Re Application No: BR/194/17/PL

I have reviewed the amendment to the above application on your website, and would like to make further representation as follows.

North Elevation
1 : 50

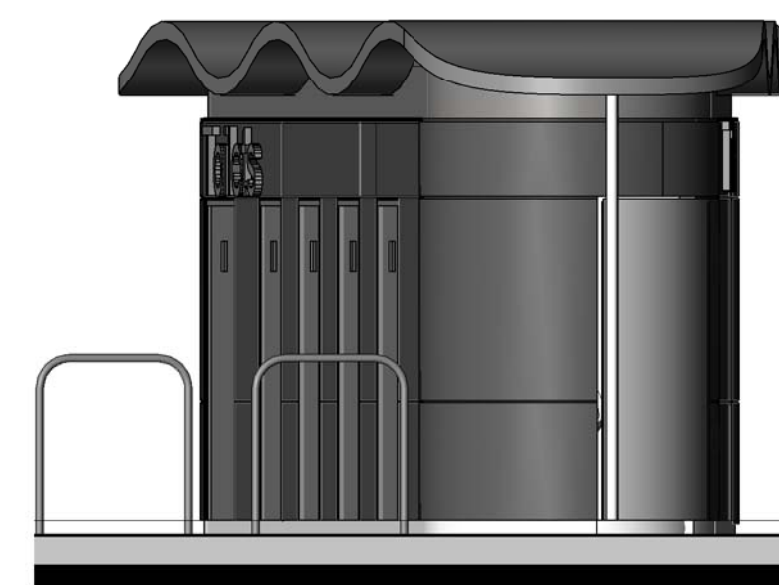
Whilst I still object to the siting of the toilets in the proposed position, the amendments are an improvement to the original application. However, I feel the signage proposed for the north facing exterior is oversized, and not in keeping with the general signage of the area. I feel that the signage would be better restricted to EAST/WEST and SOUTH facia only, which would be more informative for the promenade users, and would provide a better outlook for residents of the Esplanade.
